REFUSAL OF PLANNING PERMISSION

APPLICATION NO. 2019/1572

Proposal Conversion of former public house into 10 no. flats.

At The Goldthorpe Hotel, Doncaster Road, Goldthorpe, Rotherham, S63 9JA

Basement plan

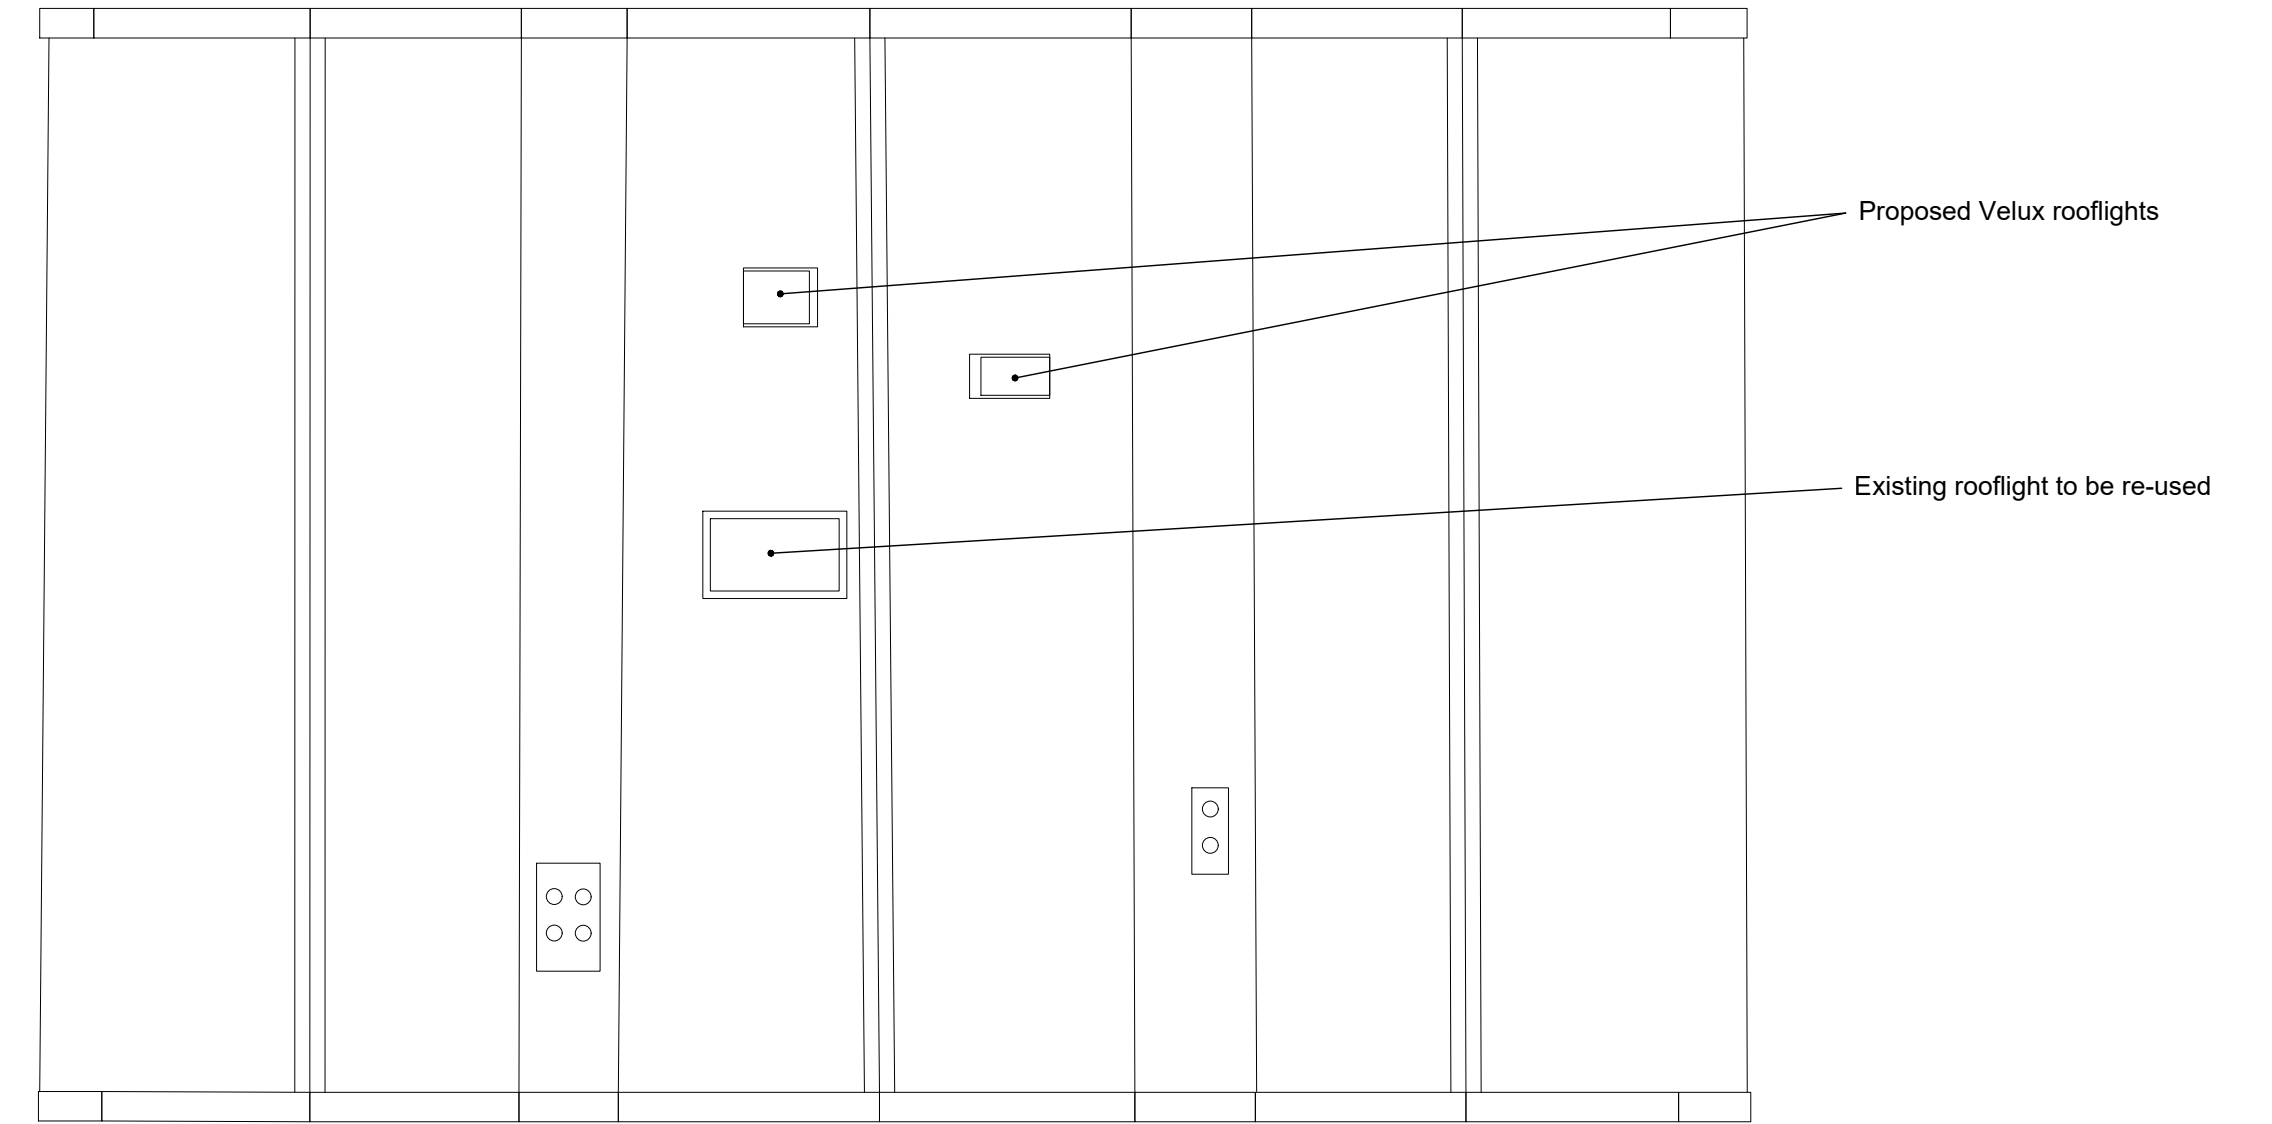
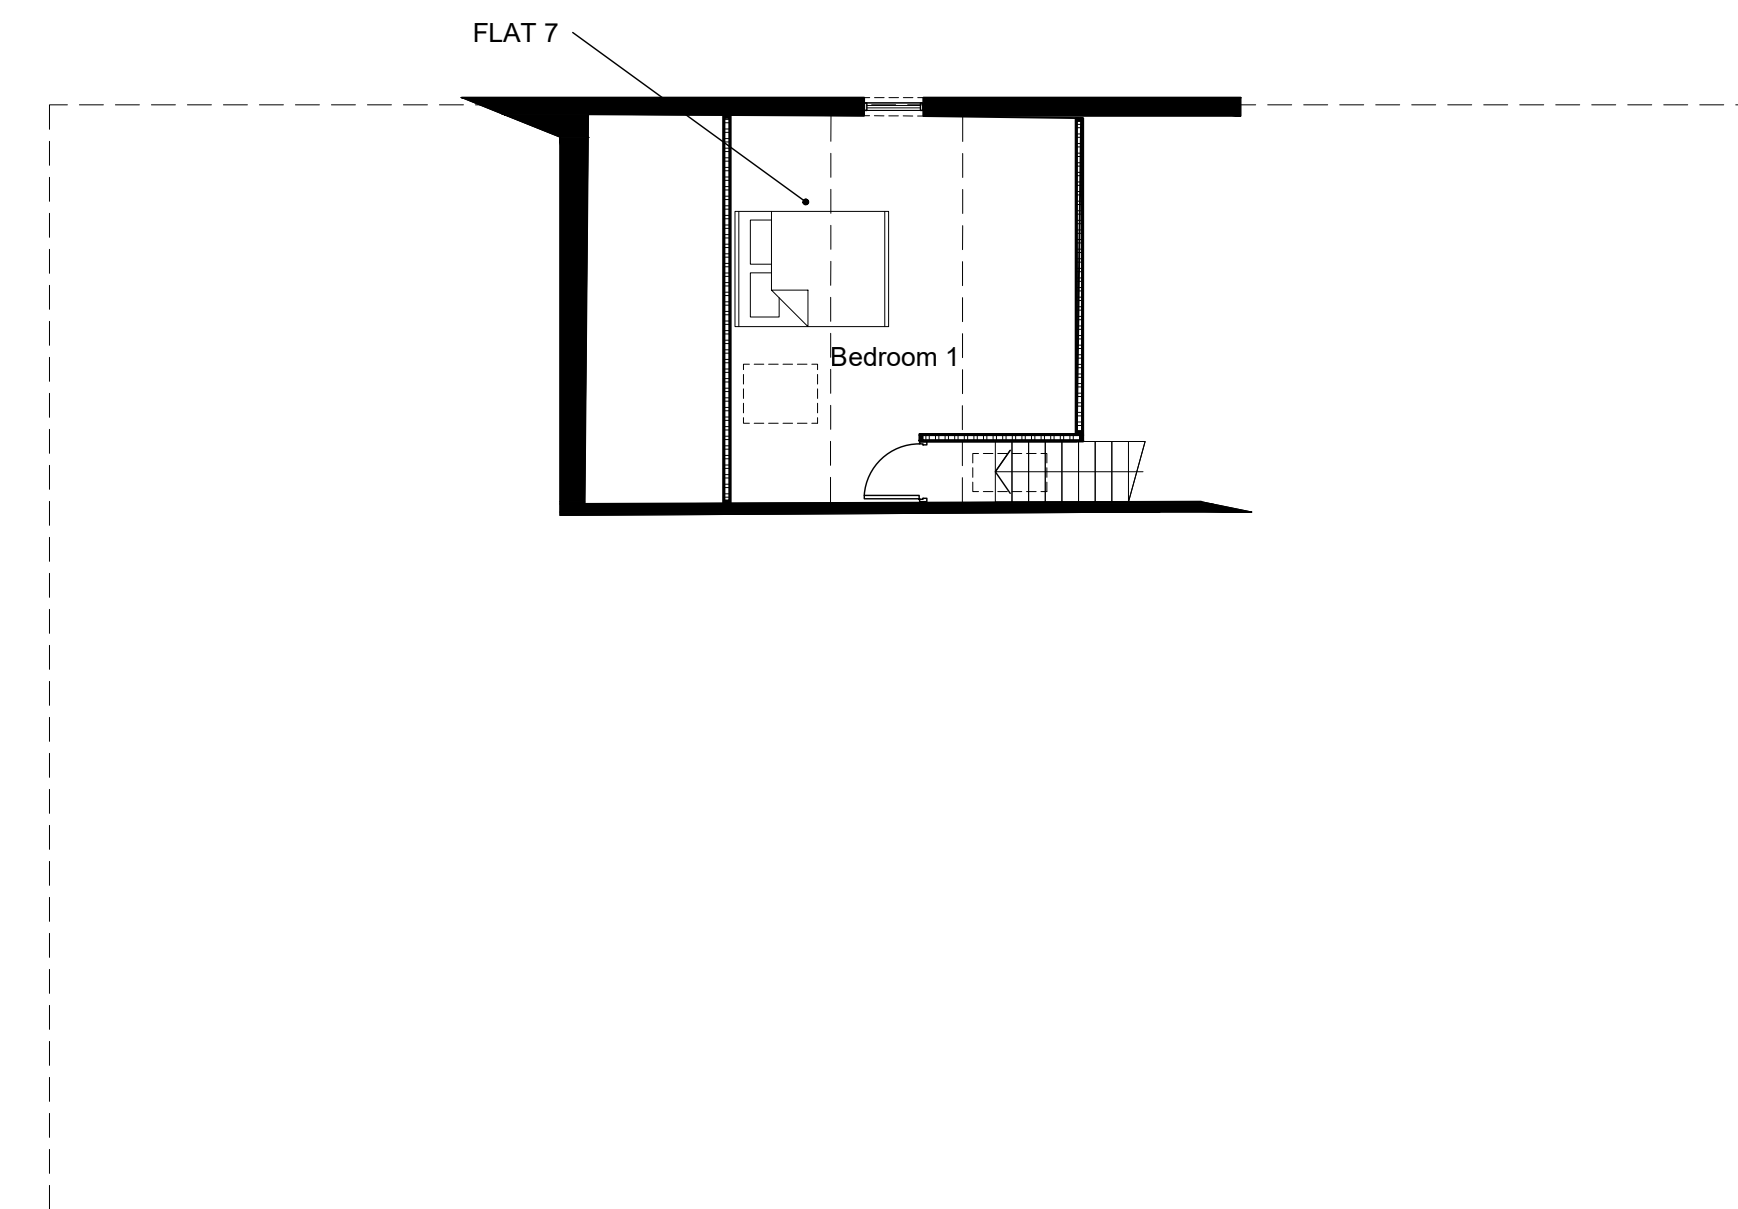
- 2 In the opinion of the Local Planning Authority, the proposed development will detrimentally impact the privacy of a neighbouring property (no. 135 Barnsley road) by virtue of the side elevation windows serving the habitable rooms of flats 1 and 9, respectively, being situated at a very close proximity (14 metres) to the existing habitable room windows located on the side elevation of no. 135. This in turn will have adversely affect the residential amenity enjoyed by this neighbouring residential property, contrary to SPD: Design of Housing Development and Local Plan Policy GD1: General Development.
